# Rezoning Transportation Analysis

Petition Number: 2023-015

**From: Jake Carpenter, PE**  
Jacob.Carpenter@charlottenc.gov  
980-221-5675

Date	Description
5-24-23	First Review (JT)
10-26-23	Second Review (JP)
12-20-23	Third Review (JP)
2-28-24	Fourth Review (JP)
3-26-24	Fifth Review (JP)
4-23-24	Sixth Review (JP)

RZ - 200

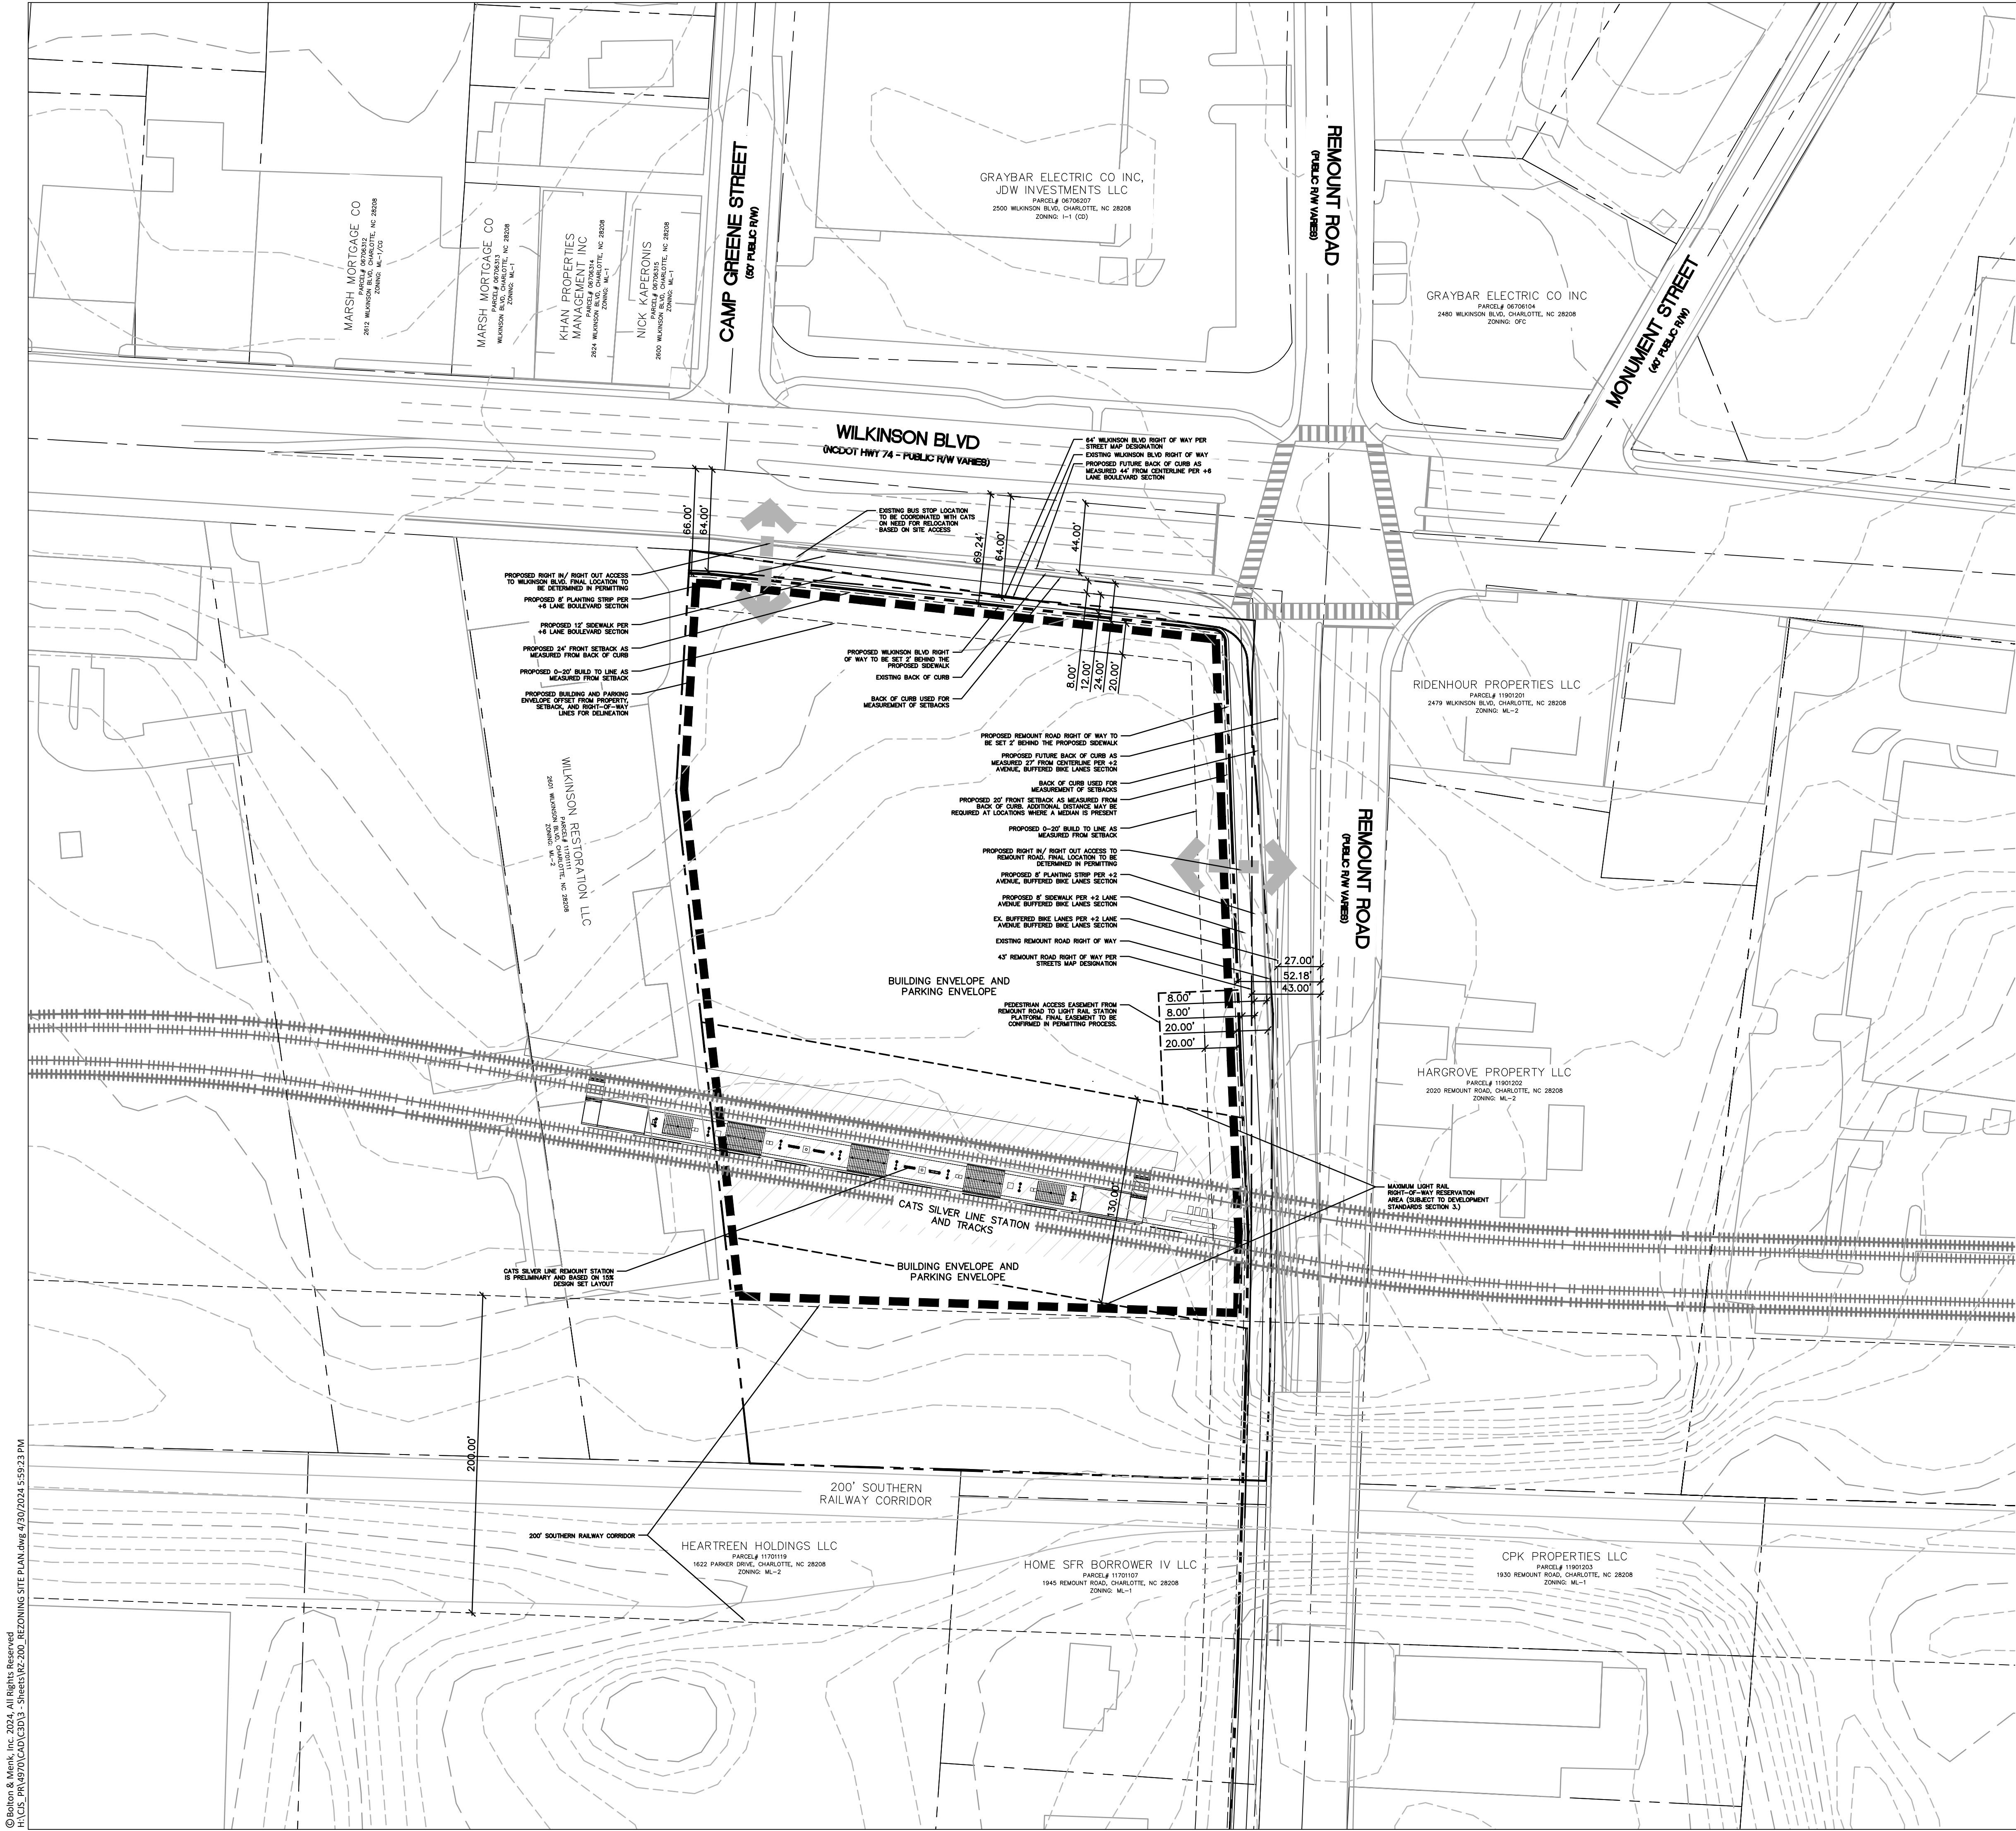
~~**Outstanding Comment 12.20.23:** Label and dimension the curb and gutter from the centerline for each road on the site plan.~~

~~3. Revise site plan and conditional note(s) to label and dimension the right of way from the road centerline.~~

a. ~~**Wilkinson Boulevard:** the future location of curb and gutter is in its existing location.~~

b. ~~**Remount Road:** the future location of curb and gutter is in its existing location.~~
